Recommendation Report for Planning Permission for Works or Extension to a Dwelling

REF NO: EP/92/18/HH

LOCATION: 14 Somerset Road
East Preston
BN16 1BZ

PROPOSAL: Demolition of a single storey section at rear of house, demolition of a shed in rear garden & erection of a two storey rear extension.

PROPOSED 2 STOREY REAR EXTENSION
14 SOMERSET ROAD, EAST PRESTON, BN16 1BZ
PROPOSED FRONT AND REAR ELEVATIONS
SCALE – 1:50 @ A3
DATE – 16/05/2018
DRAWN – H.WILMAN
DRWG NO – SOM-08

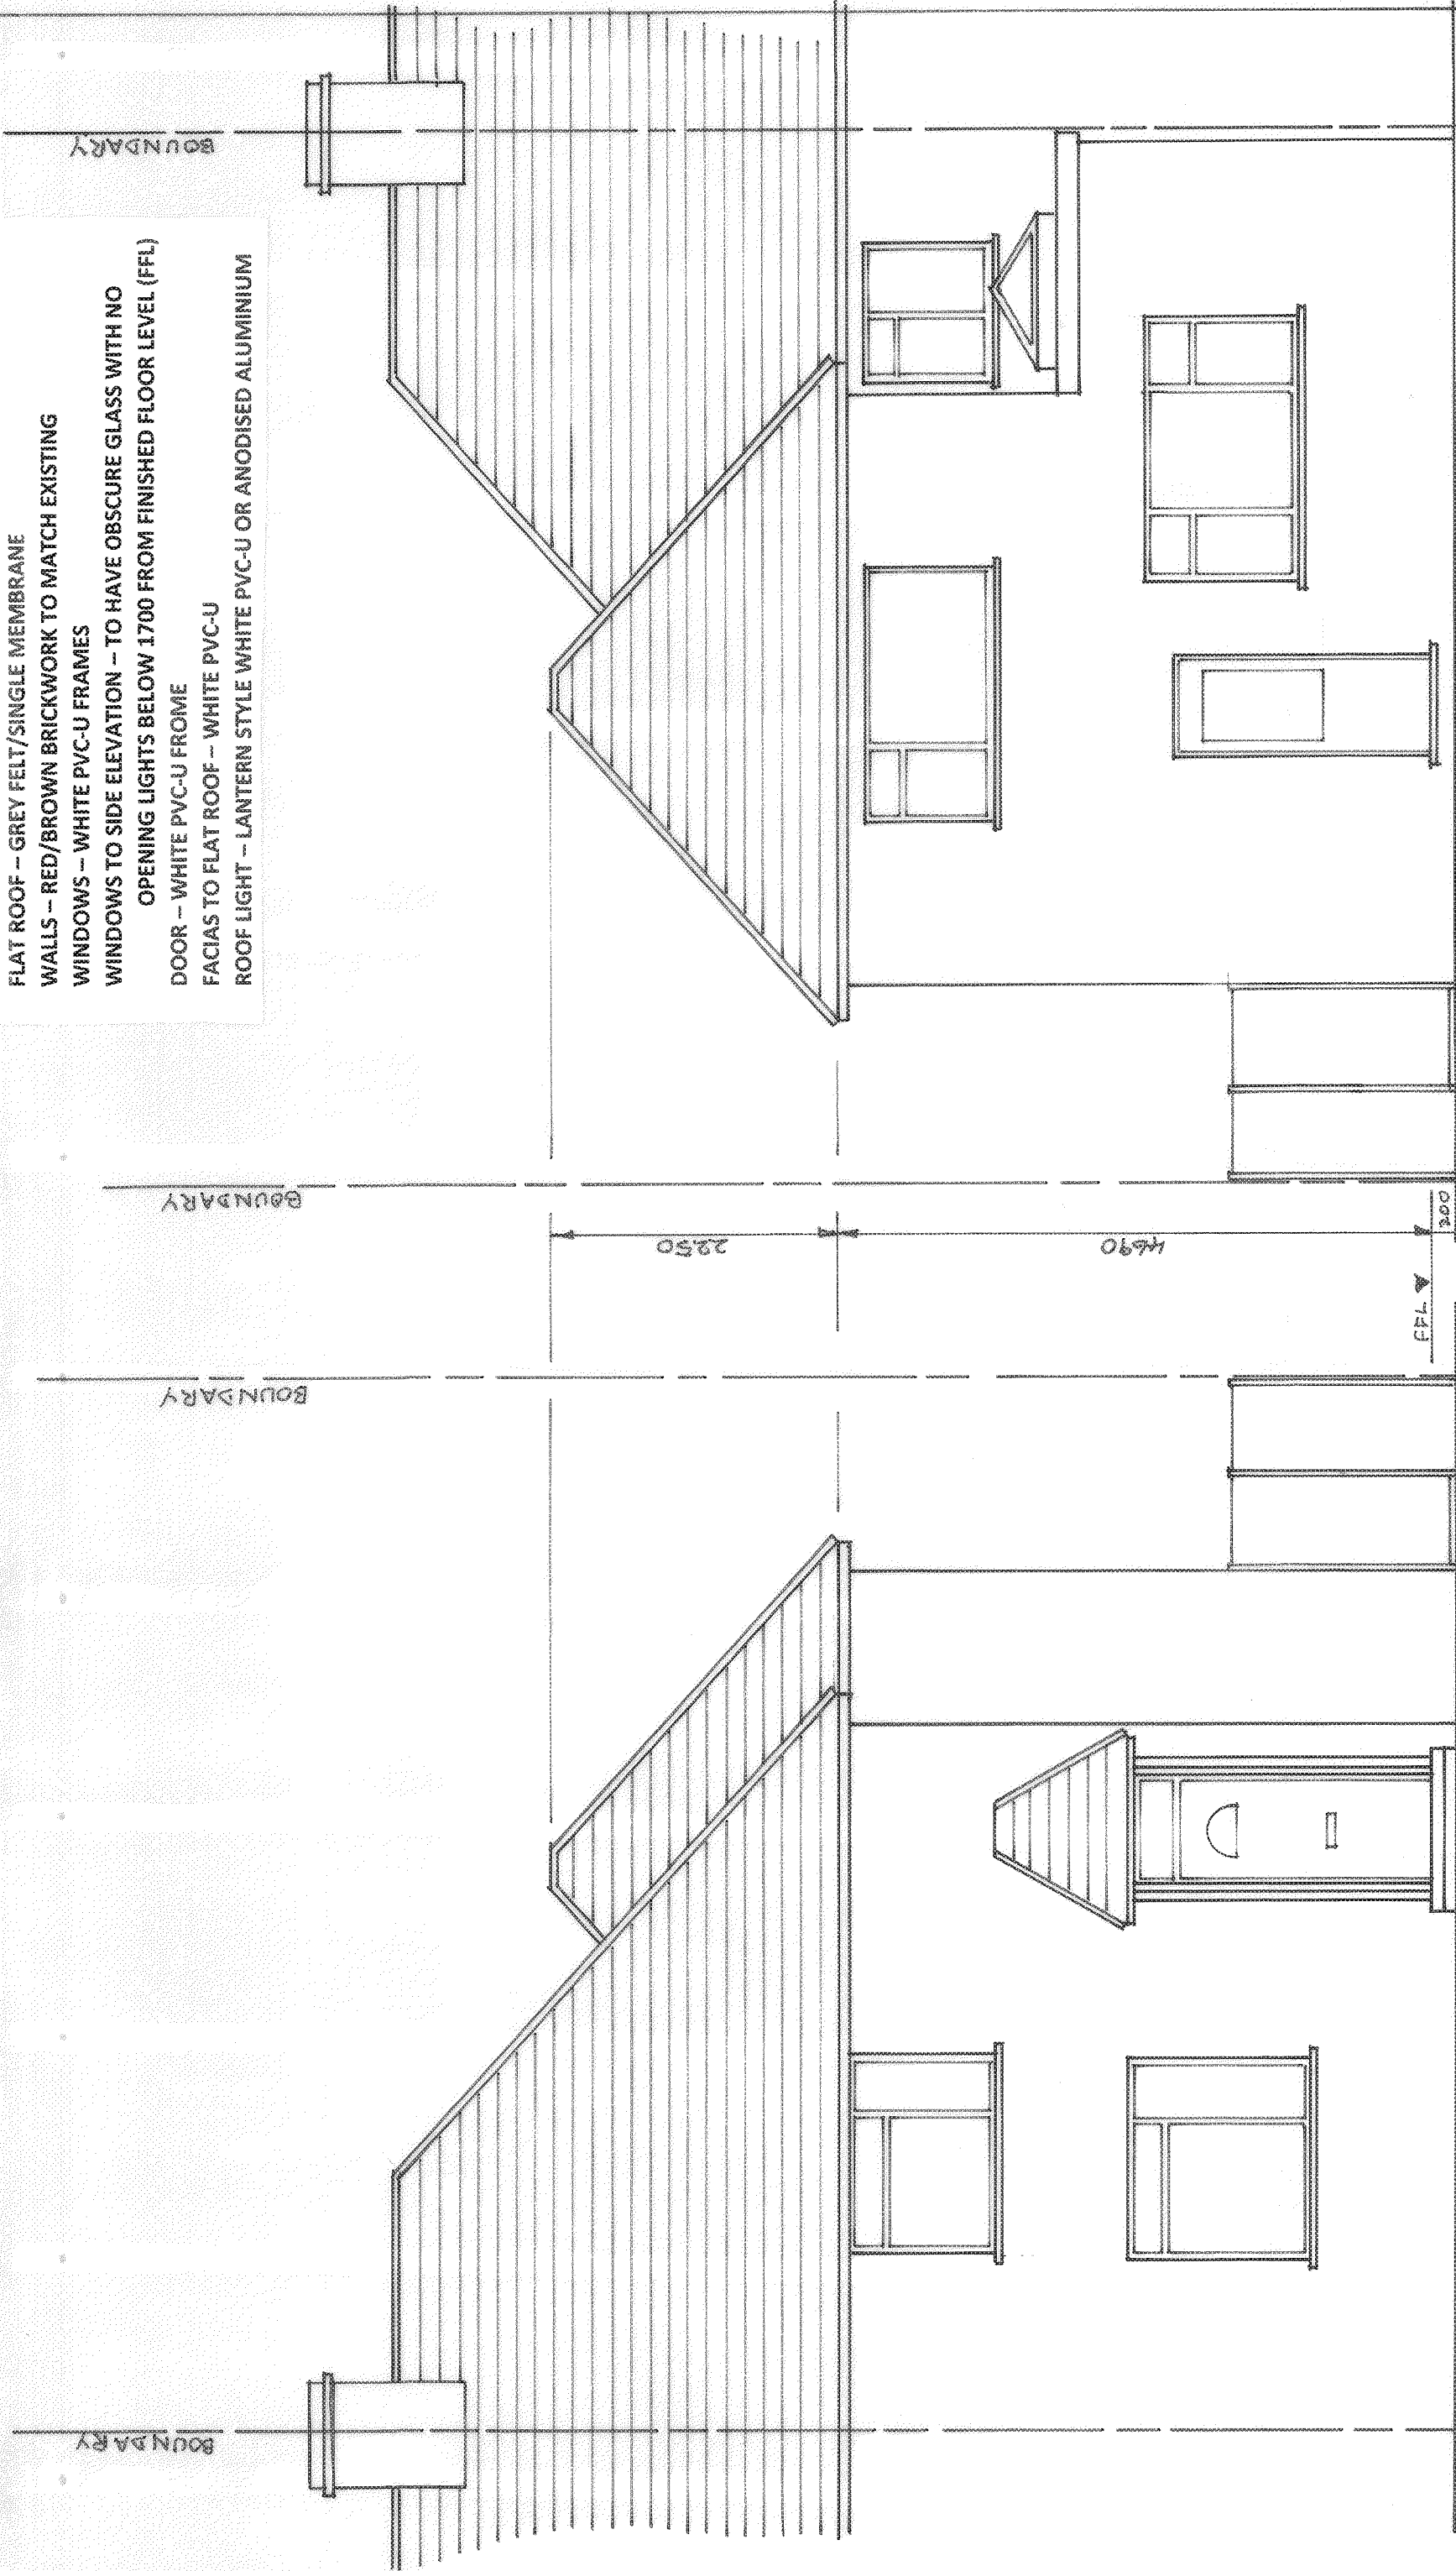
The proposed extension is considered to alter the appearance of the dwelling, as a result of its scale. Whilst the proposed extension is considered to be well integrated with the host dwelling, it is not considered to be a sympathetic or subservient addition to the host dwelling. This is predominantly as a result of its significant scale and impact on the appearance of the dwelling. Therefore, the proposed development is deemed to be in conflict with D DM4(a) and (b) of the Arun District Council Local Plan (2011-2031).

aspect of the dwellings and the spacing between the buildings, the proposal is not considered to have any significant impact on overshadowing, overlooking or have an overbearing impact on adjacent occupiers. Whilst it is noted that there is a change in fenestration on the rear elevation, it is not considered that this will result in any change relating to loss of privacy to neighbouring properties. Resultantly, the proposed development is considered to be in accordance with D DM1(3) and D DM4(c) of the Arun District Council Local Plan (2011-2031).

PROPOSED 2 STOREY REAR EXTENSION
14 SOMERSET ROAD, EAST PRESTON, BN16 1BZ
PROPOSED SECTION ON BOUNDARY
SCALE – 1:50 @ A3 DRAWN – H. WILMAN
DATE – 16/05/2018 DRWG NO – SOM-10

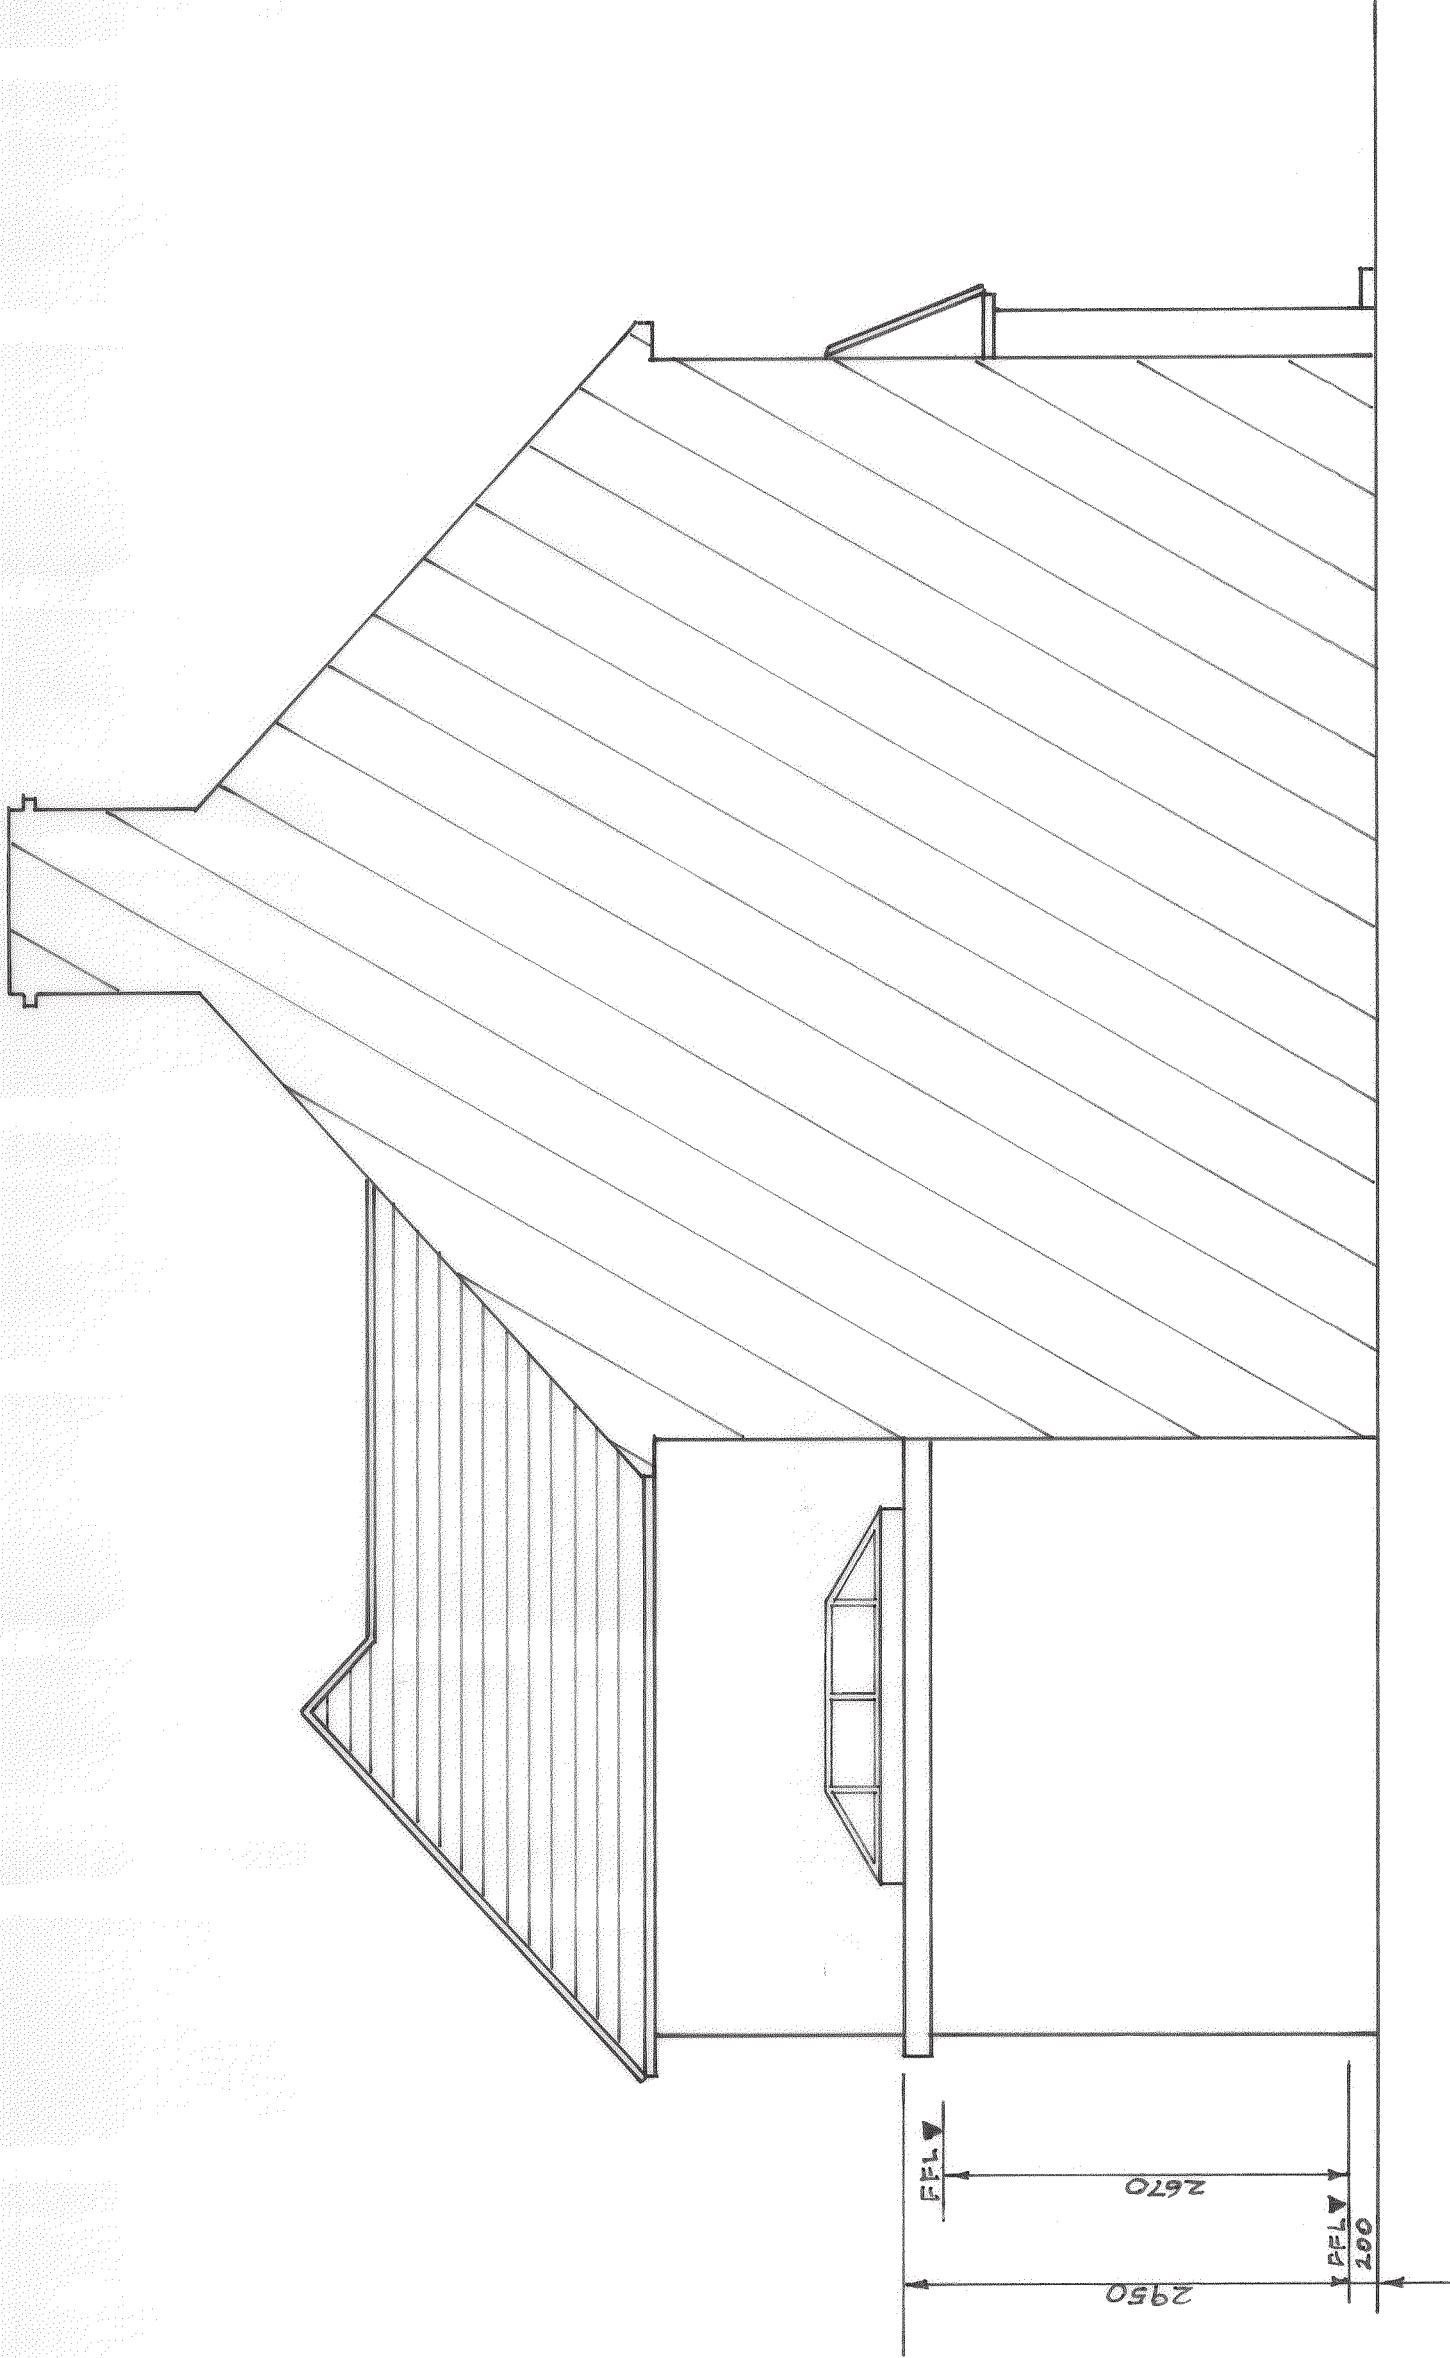
The proposed development will be 4.7m high at the eaves and 7m high at the ridge. The total width will be 4.5m and it will extend 4.5m out from the rear of the existing house. In the 2m space between the two storey aspect of the rear extension and the shared boundary with #13, there is a single storey extension. This extension is flat roofed, with a height of 3.1m (3.6m at a rooflight), this is considered to alleviate any possible overbearing impact of the dwelling on the occupiers of this neighbouring dwelling. Due to the
